CITY OF ALBUQUERQUE

**Re: Andaluia Villas, Tract 4 and 6 North Andaluia
Grading and Drainage Plan
Engineer's Stamp Date 6/04/2012 (E12/D015C)**

Based upon the information provided in your submittal received 8/07/2012, the above referenced submittal can not be reviewed for Building Permit Approval until the following comments have been addressed:

**DRAWING NAME**  
 POND 'A'  
 GRADING  
 PLAN

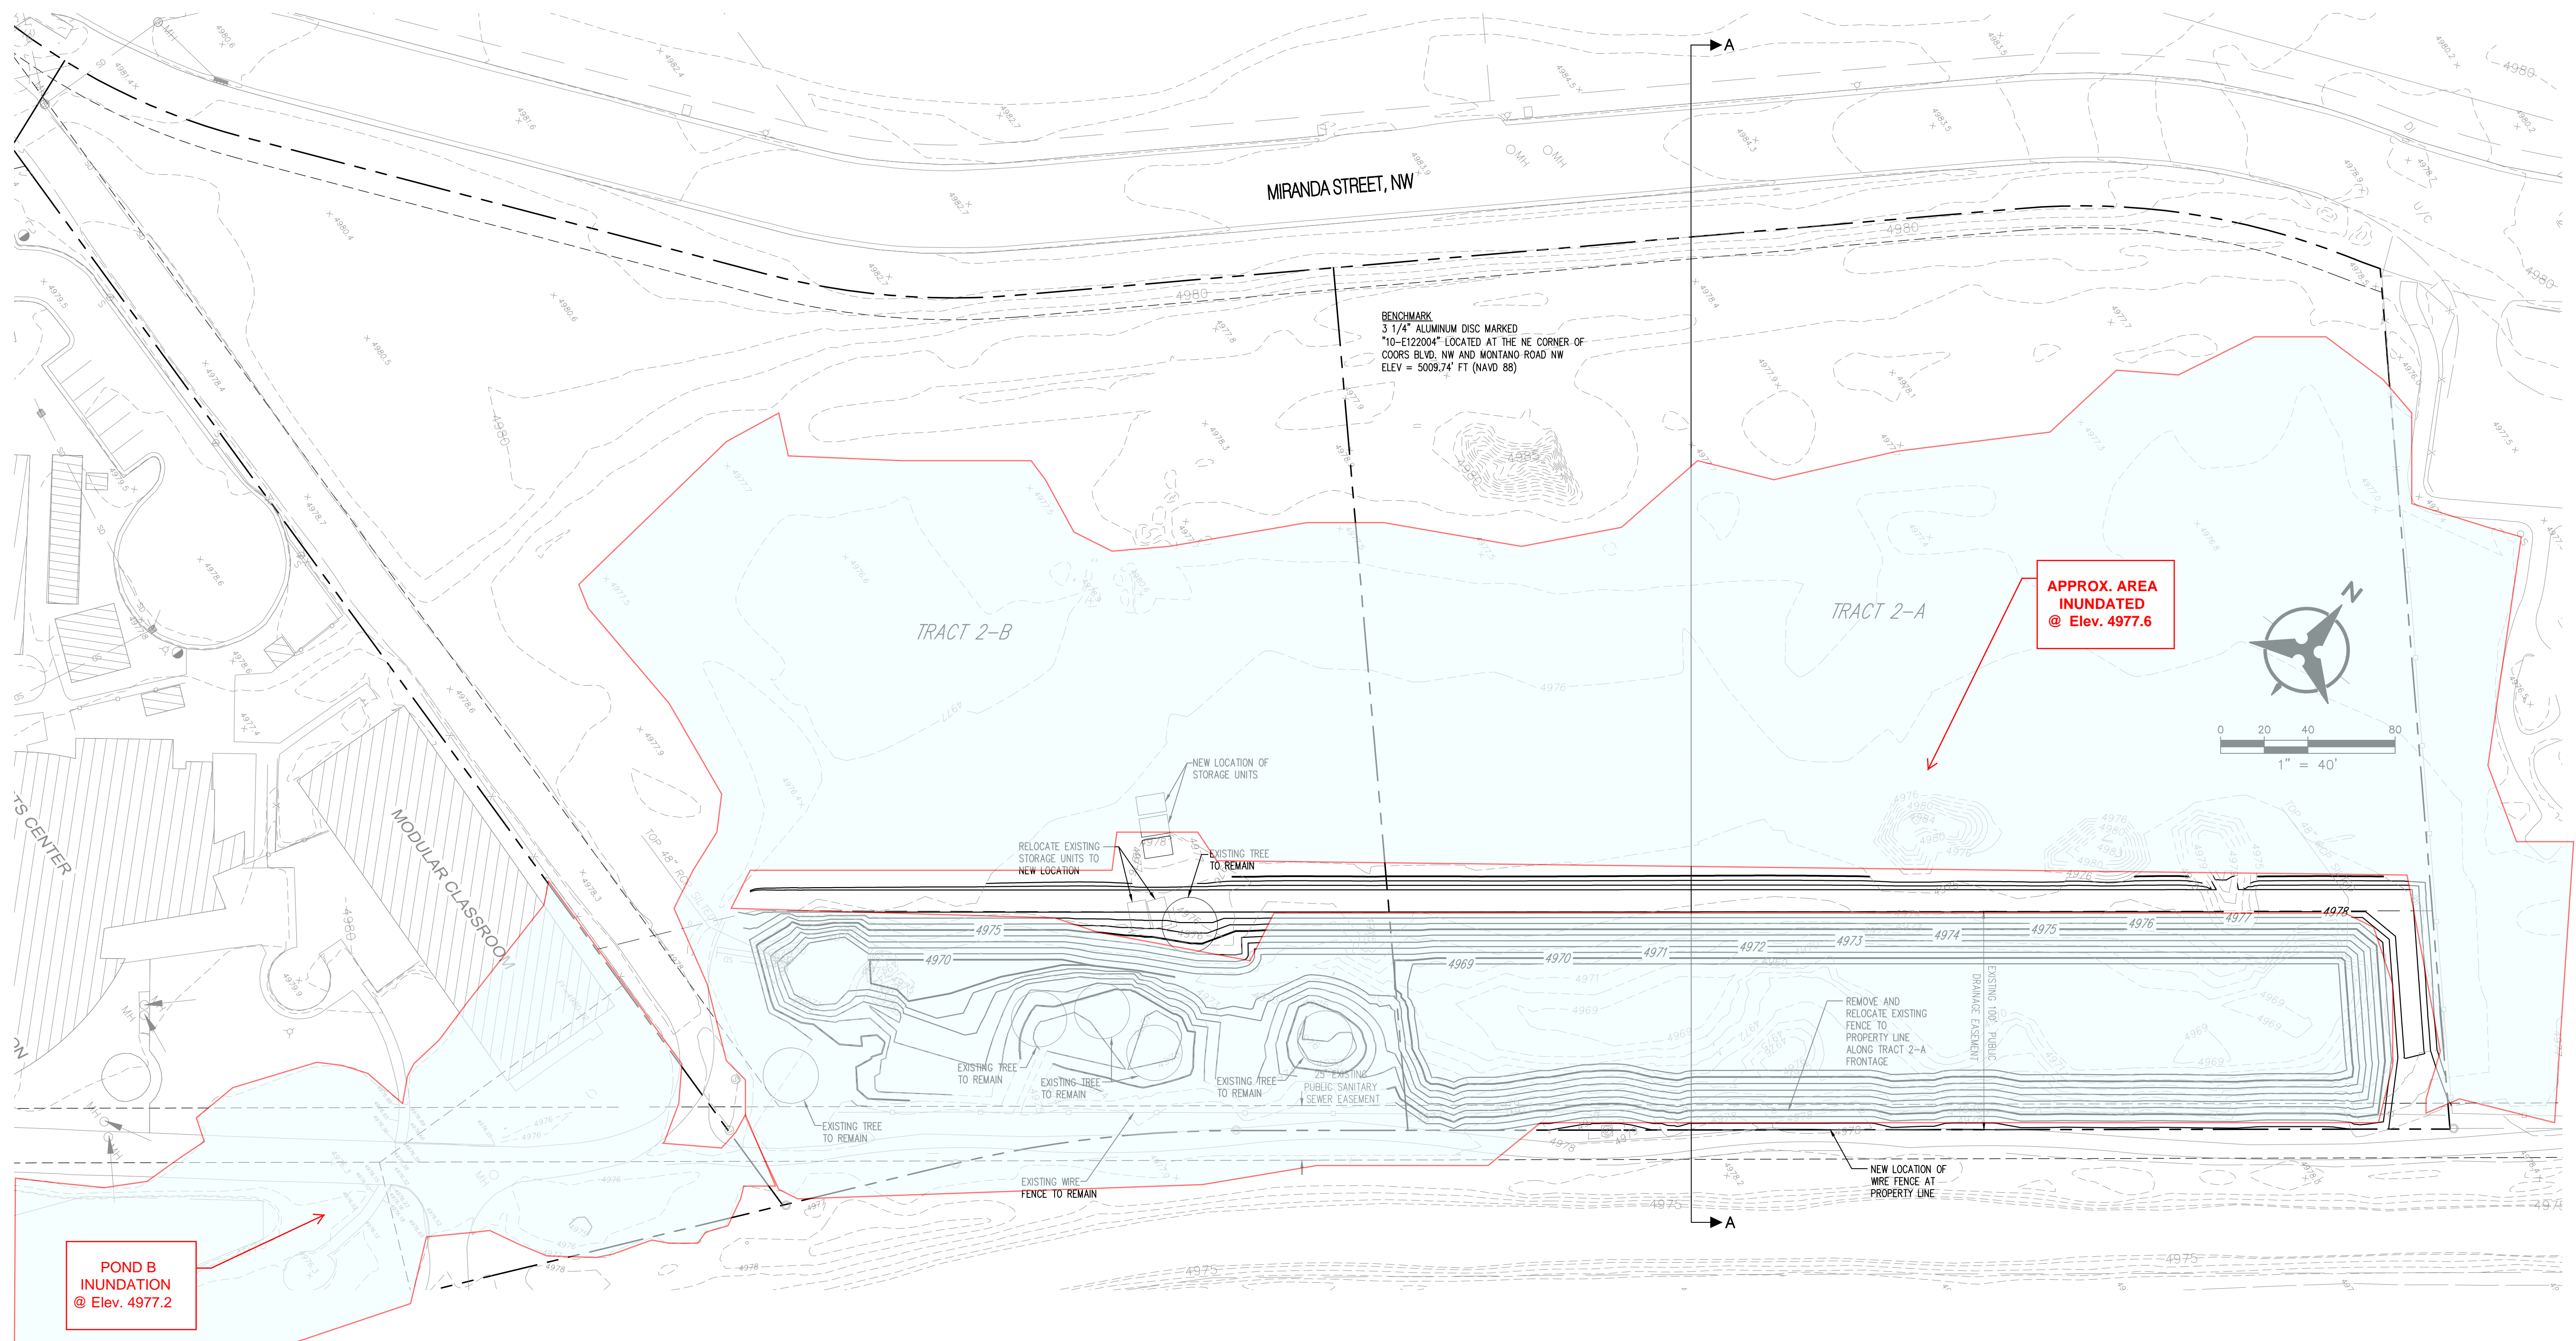
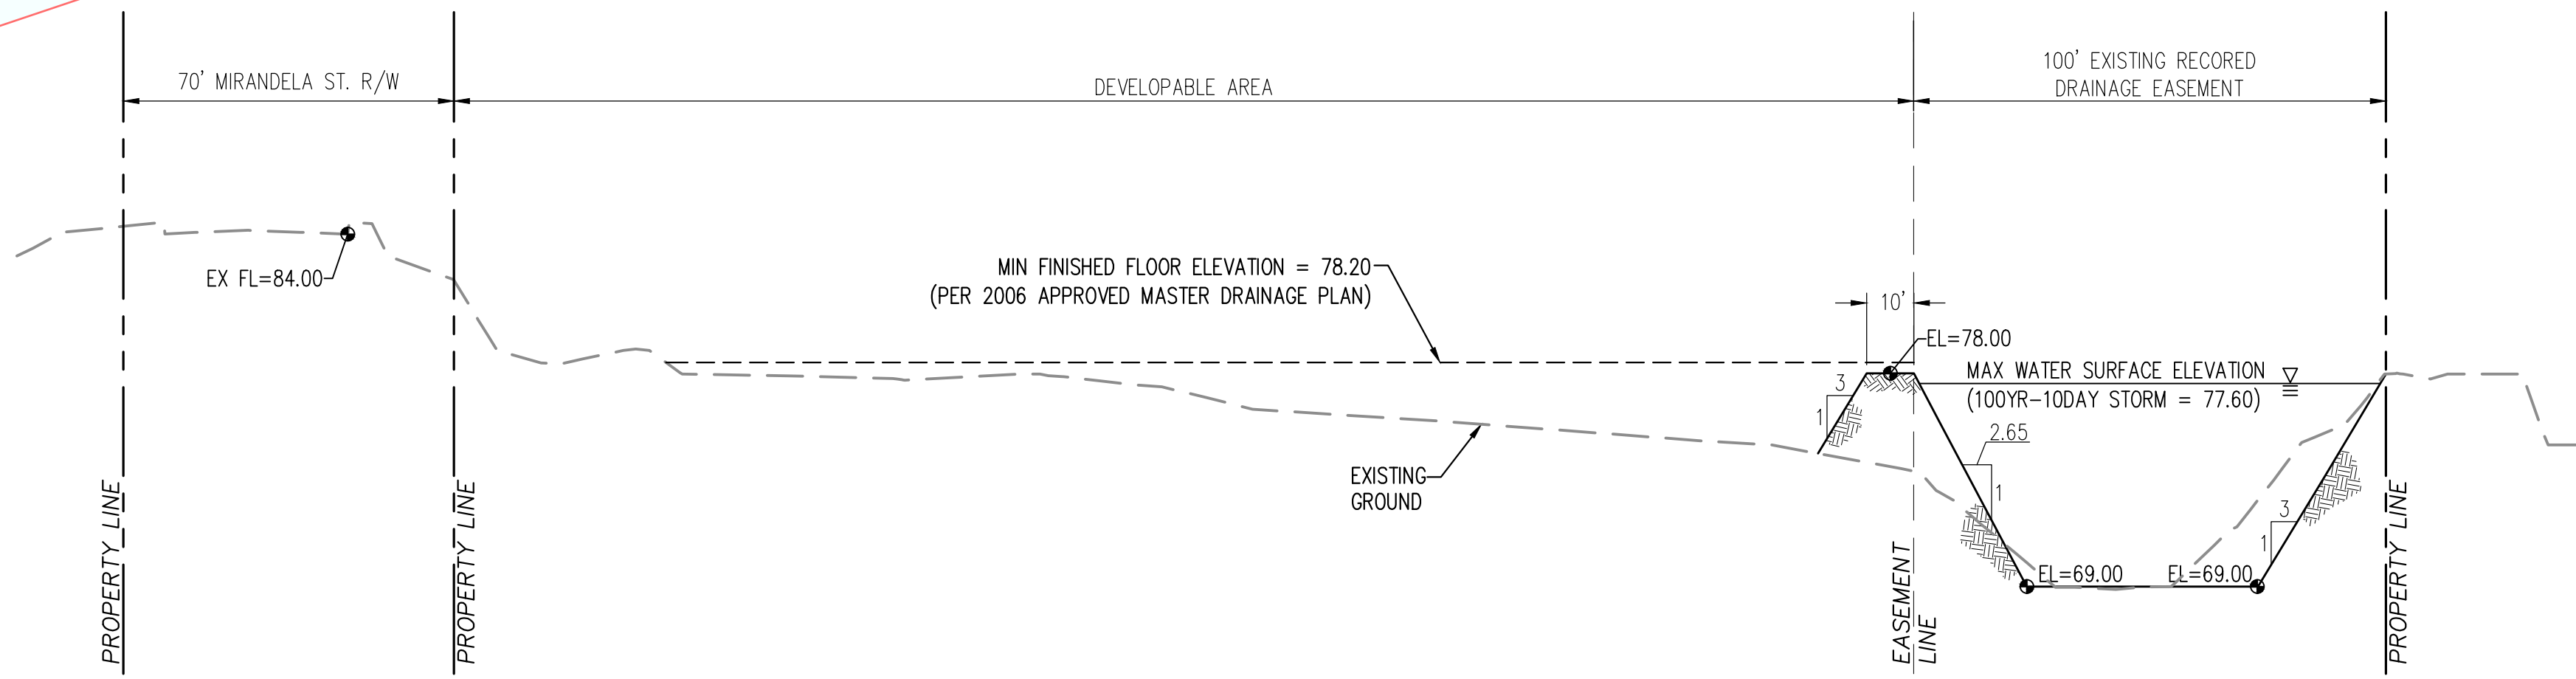
- The existing retention pond (Pond B) located on the east of the school has to be reanalyzed to assure it has adequate ponding capacity as it was intended on the Master Drainage Plan. Retention Ponds may be required for Andaluia Villas.
- The overflow from existing pond north of the school site (Pond A) to Pond B may have to be constructed. Does Pond A have to be regarded?
- Recorded drainage easement is required for Pond B.
